Re: 4719 86th Ave SE
Mercer Island, Washington
SUB 23-004

This letter provides the geotechnical engineering-related comments for the above-referenced permit.

The Lorenzini short plat documents (SUB 23-004-SUB1) were reviewed.

Michele Lorilla, P.E.
Geotechnical Peer Reviewer

DRAWING: C4  
 SHEET: 4 OF 4

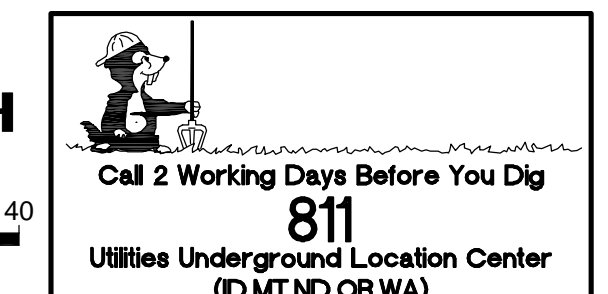
The proposed location of the stormwater detention tank shown on Sheet C4 should be reviewed by the geotechnical engineer of record. An assessment of both the potential long-term impacts from the detention system on the stability of the slope given its proximity to the edge of the slope, as well as the potential adverse impacts of future slope movements on the performance of the detention system should be provided.

Following review of the plans, assessment of the detention tank location, and recommendations for alternate detention system location, if applicable, a letter should be provided stating whether the current plans conform to the geotechnical engineer's site development recommendations. An updated statement of risk (MICC19.07.160.B.3) from the geotechnical engineer should also be included in the letter.
